CITY OF PORTLAND BUILDING PERMIT

PERMIT ID: 2012-65593

RE: Building Permit Application – Portland Community Health Clinic Renovations,
180 Park Avenue, Portland, Maine

Portland Community
Health Clinic- Renovation
Project

3a Typical Infill partition to Match Existing Construction
 1 HOUR RATED

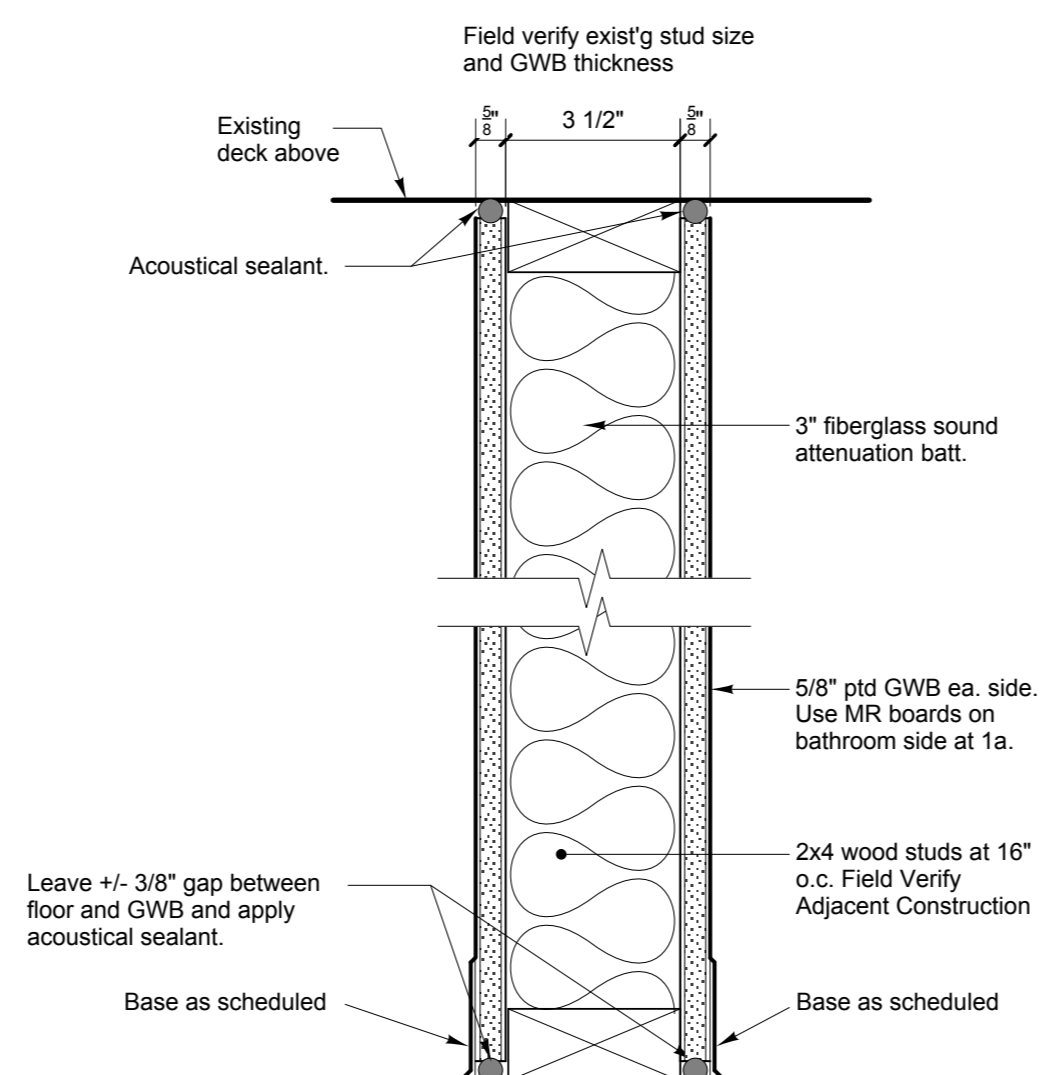
I'm following up on our telephone conversation today regarding the above referenced project. Per your previous review comments we are required to provide a 1 hour rating on corridor walls and ceilings with 20 minute rated doors w/ closers for the corridors within the tenant space. This requirement is described in NFPA chapter 38, article 38.3.6 which requires rated corridors unless the building is sprinklered.

It is my understanding that it is the position of the Fire Marshal's office that exception 2 under this article stating that rated corridors are not required within a single tenant space does not apply in this instance because the space exists within a multi story, multi tenant building that shares a rated exit stair and therefore it cannot be classified as a single tenant space.

floor. Within the areas of renovation, we are proposing to provide 1 hour rated corridors with 20 minute rated doors as shown. Please note, that in the areas that are to remain as is, we are still planning to complete all smoke detector, fire alarm, and emergency lighting work shown on the original drawings so that the entire area is protected by these systems.

ASK 2

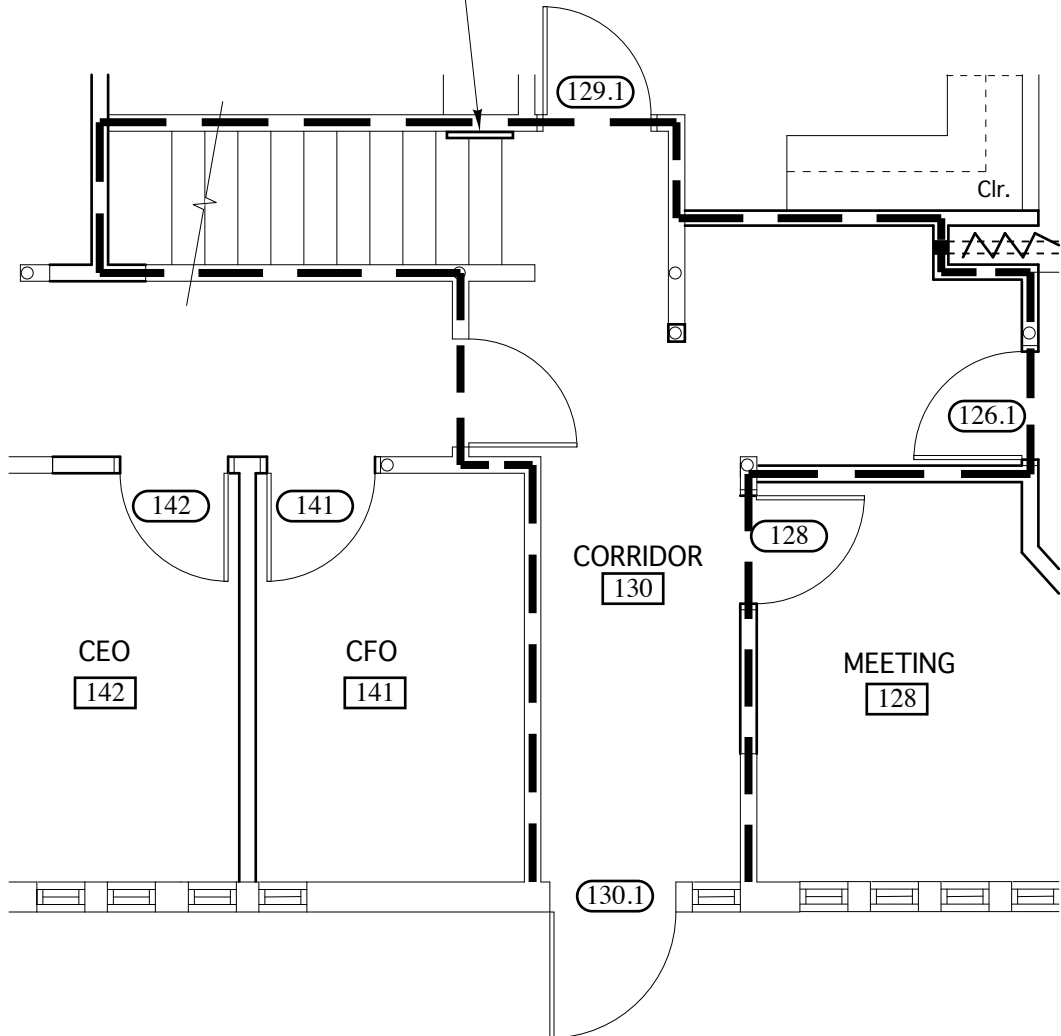
- ASK 1: clarification sketch showing how the main entrance stair is configured.
- ASK 2: shows addition of sign at bottom of interior stair indicating "not an exit"
- ASK 3: shows replacement of stair rails at exterior stair outside of door 125
- ASK 6: shows change of doors at corridor 130 to 20 min. from 60 min.
- ASK 7: shows revised floor plan indicating 1 hour corridors throughout the tenant space with 20 minute doors.

**ASK 9**

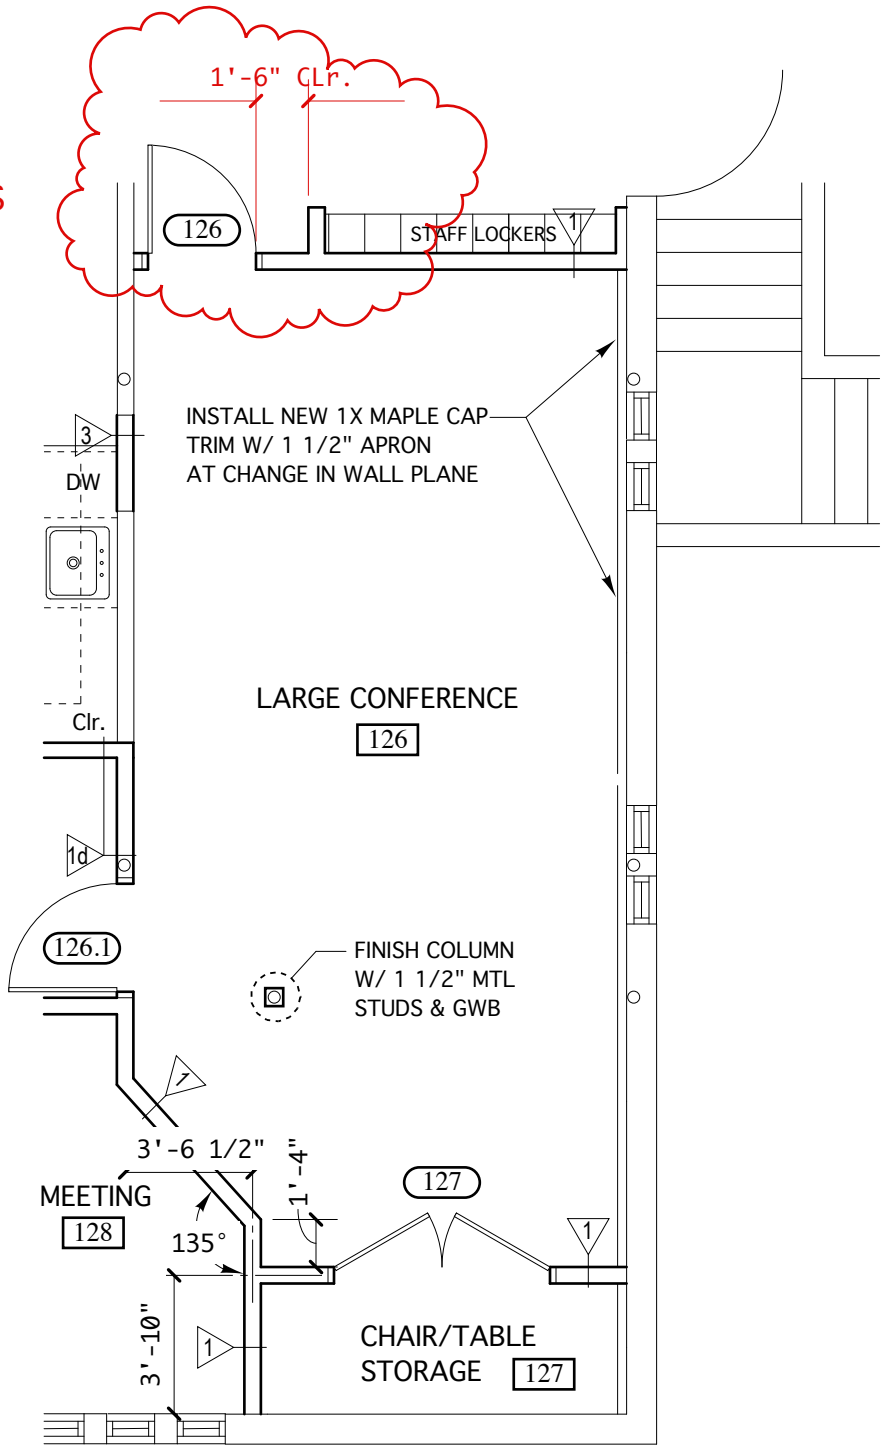
ASK 9 - Door swing changed out of Large conf. Room
